HIA Addendum

In July 2021 a Heritage Impact Assessment (HIA) report was completed as part of a Development Application (DA) submission package for a proposed Reptile & Amphibian Conservation Centre development at Taronga Zoo on behalf of the Taronga Conservation Society Australia (TCSA). Following further reviews by the TCSA, various (external and internal) architectural planning and design revisions have been made to the proposed schematic design by the architects (**dwp**). As a result of the external changes, some qualification has been required for the earlier heritage impact report.

Drawing Number
AA2000

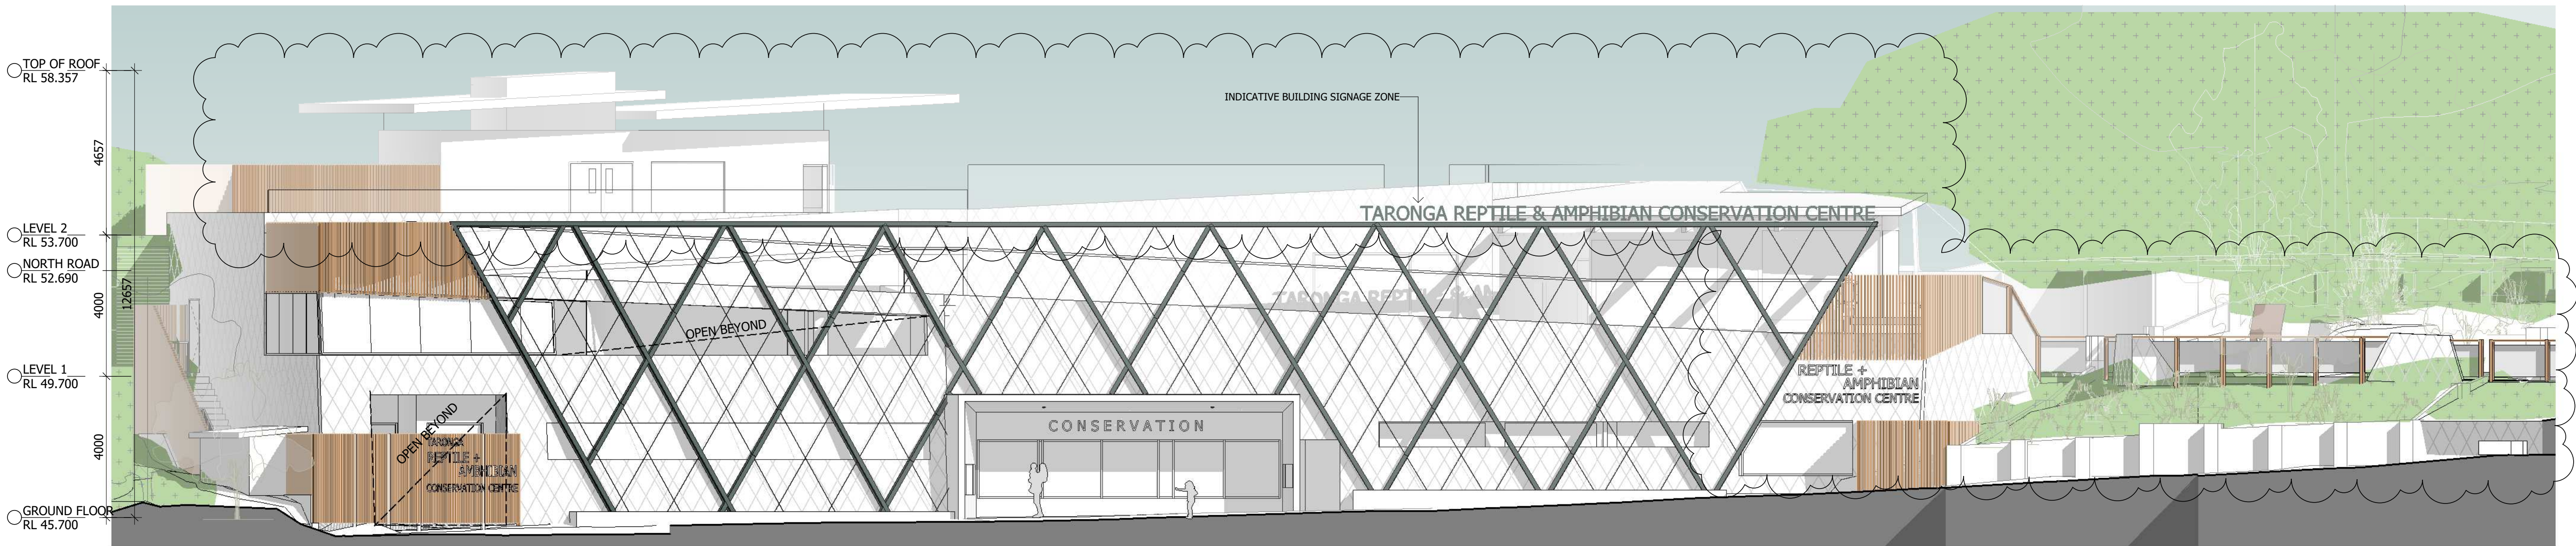
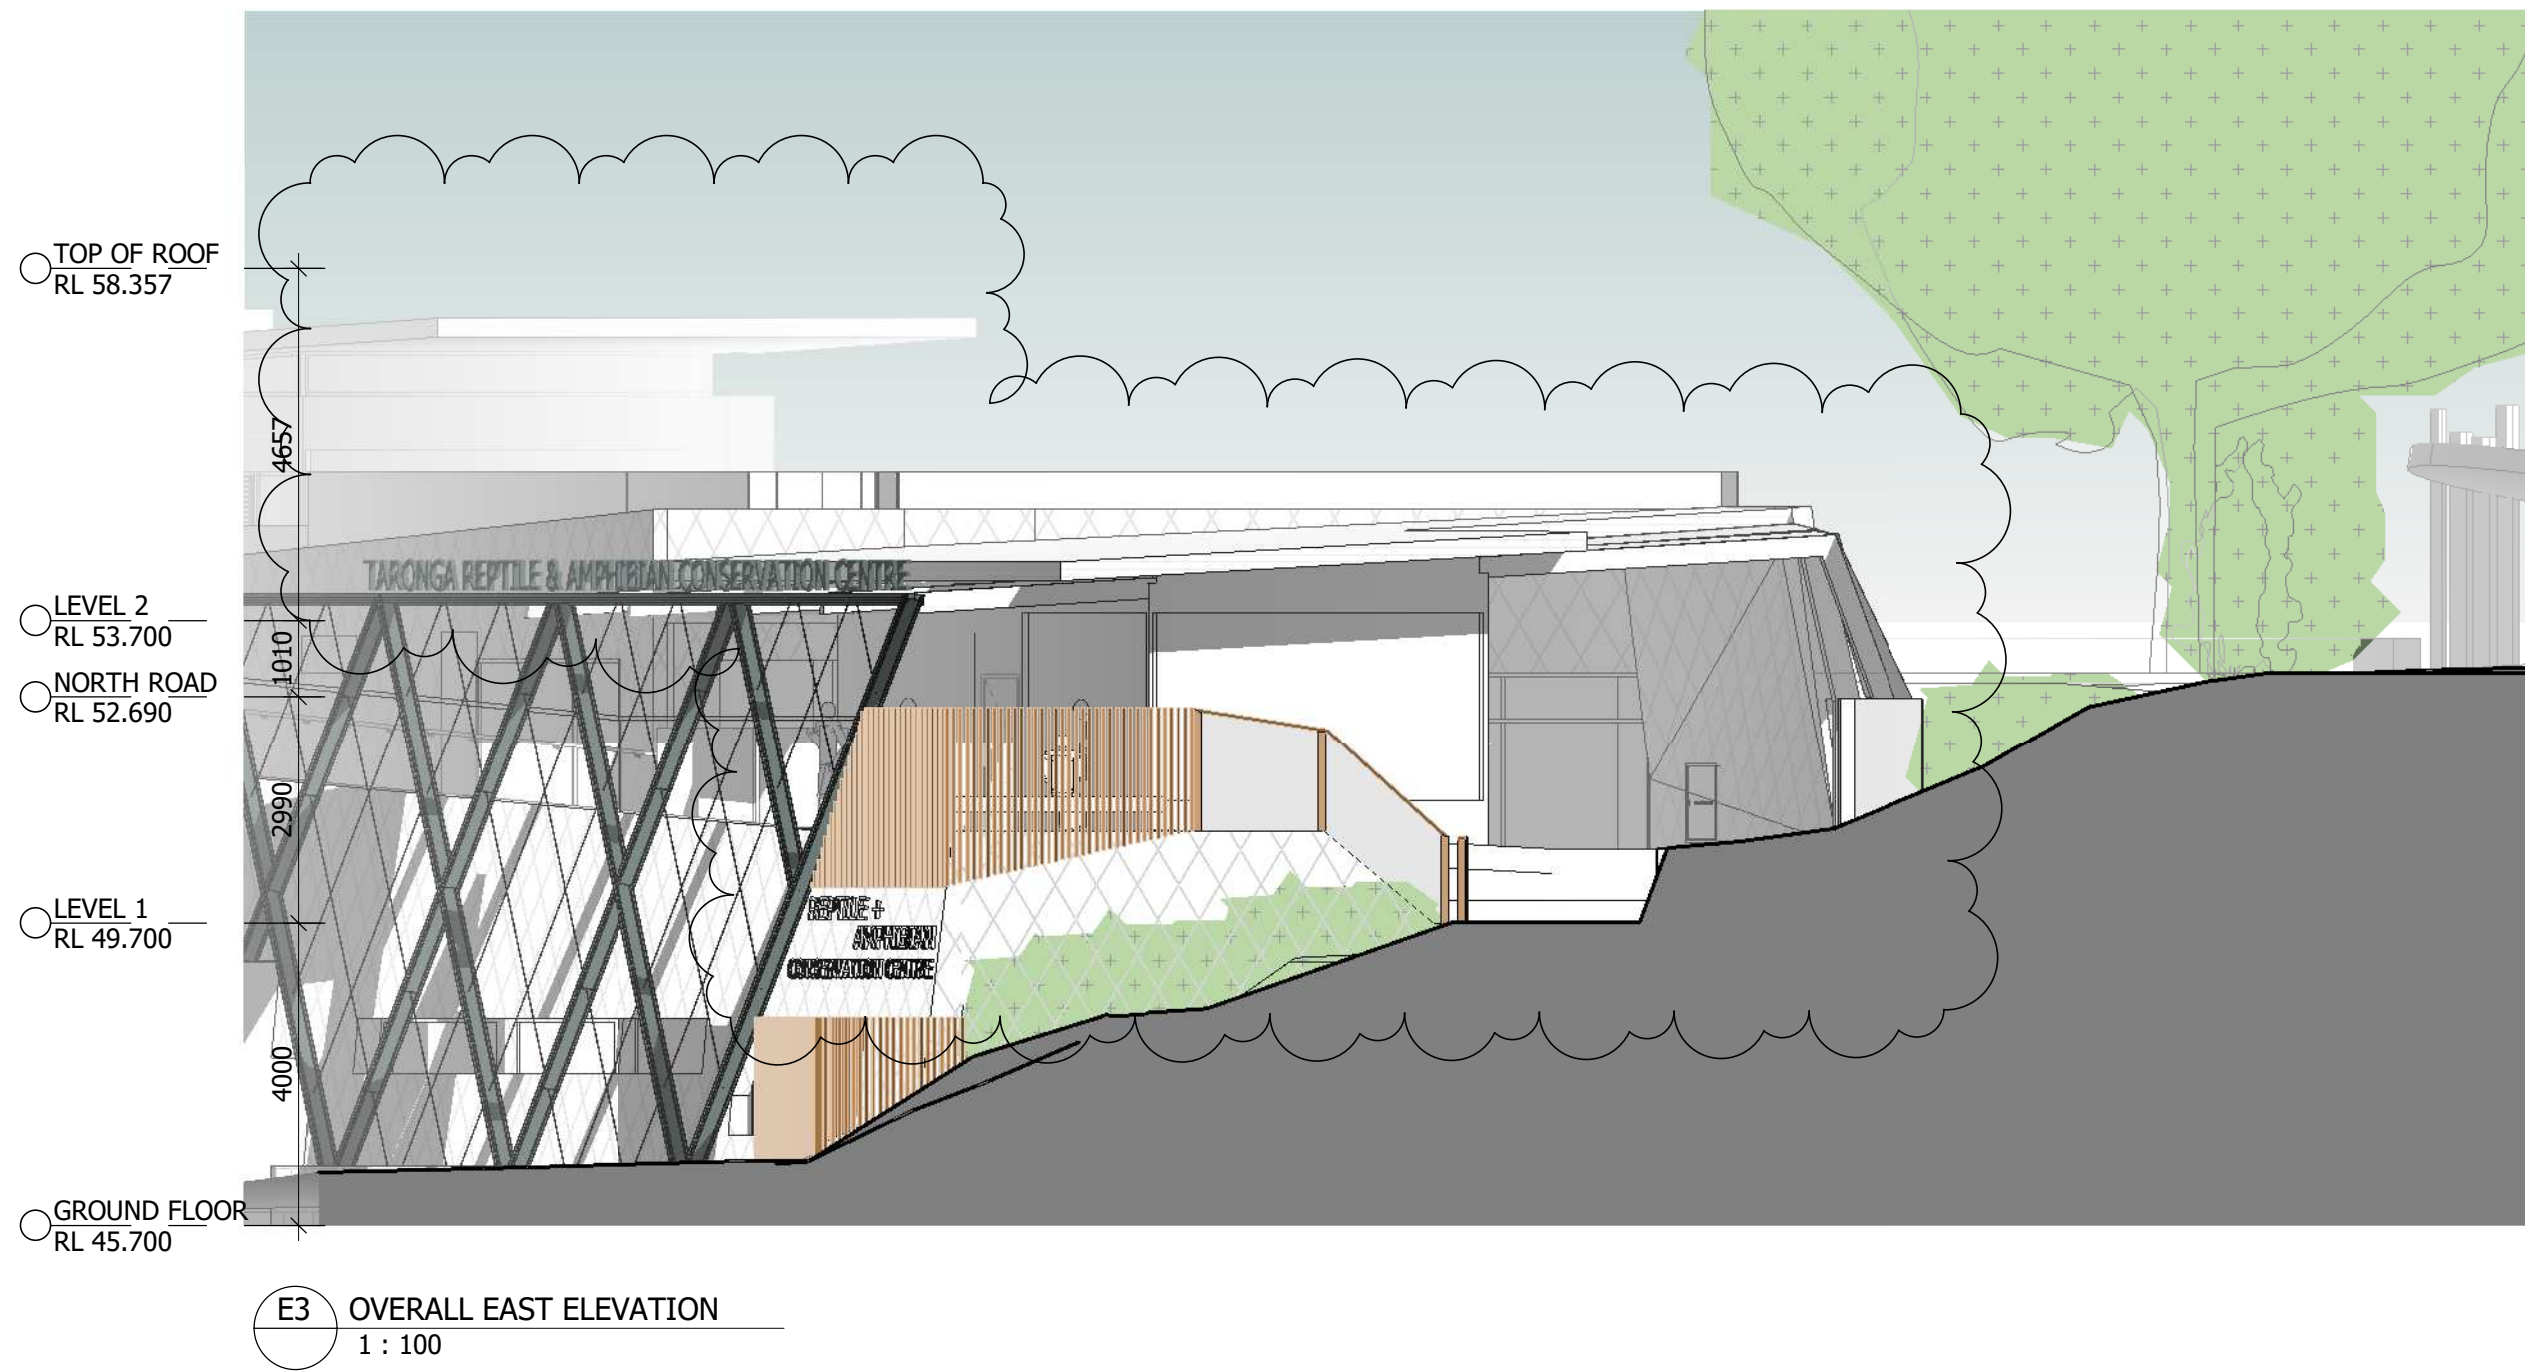
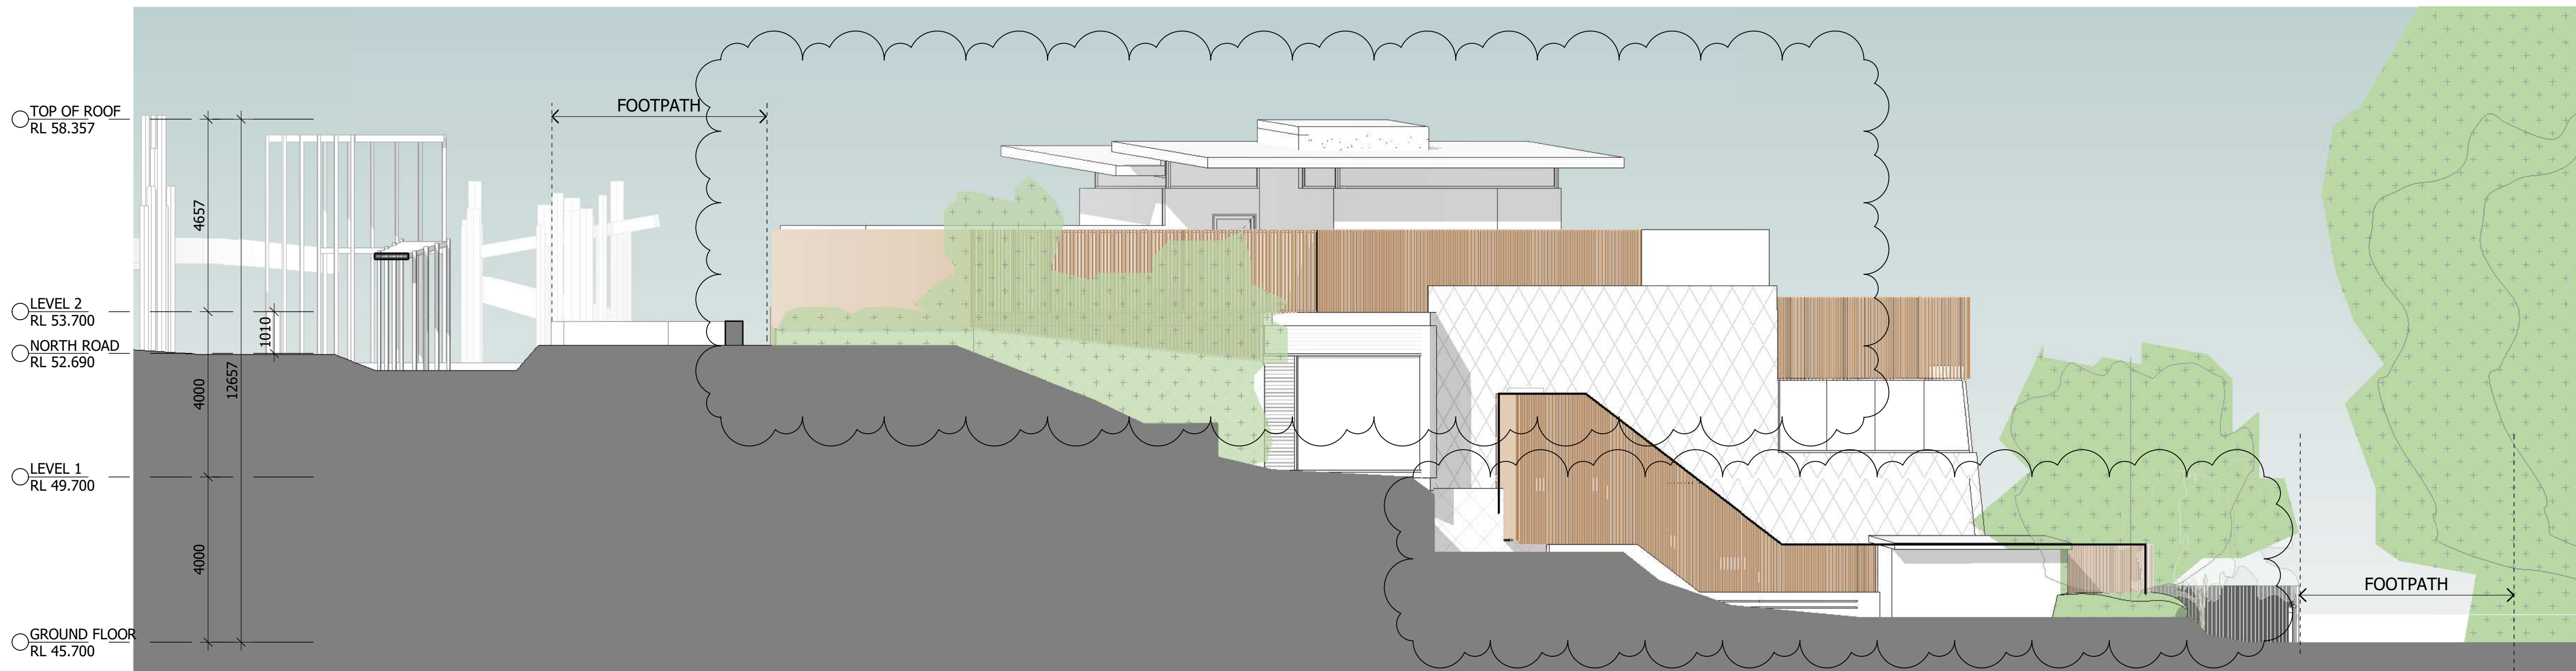
- * Revisions to the service access (no longer an internal dock area), waste store area and façade treatment at the SW corner;
- * Minor revision to the SE corner allowing views into holding area;
- * Perception of reduced bulk to west elevation through articulation of massing;
- * Additional identification sign to SE corner of building; and
- * Contraction of roof elements visible from southeast (lower level).

- * Remodelling of eastern end elevation;
- * Eastern access balustrading redesigned and now with various interpretive elements;
- * Perception of reduced bulk to eastern elevation; and
- * Eastern entry portal indicated in association with walling (entry sign) and (previous) road surface treatment.

- * Reduced to one upper level pavilion with remodelled/reduced roofs – more open area;
- * Perception of a 'flatter' elevation;
- * Deletion of translucent roofing;
- * Exit arrangement changed – ramp and steps;
- * Extent of road surface treatment reduced;
- * Increased landscape area to north;
- * Extent of building along the northern edge has decreased;
- * Extent of 'timber' façade treatment to NW increased; and
- * Reduced opportunities for visibility of the new building from the harbour.
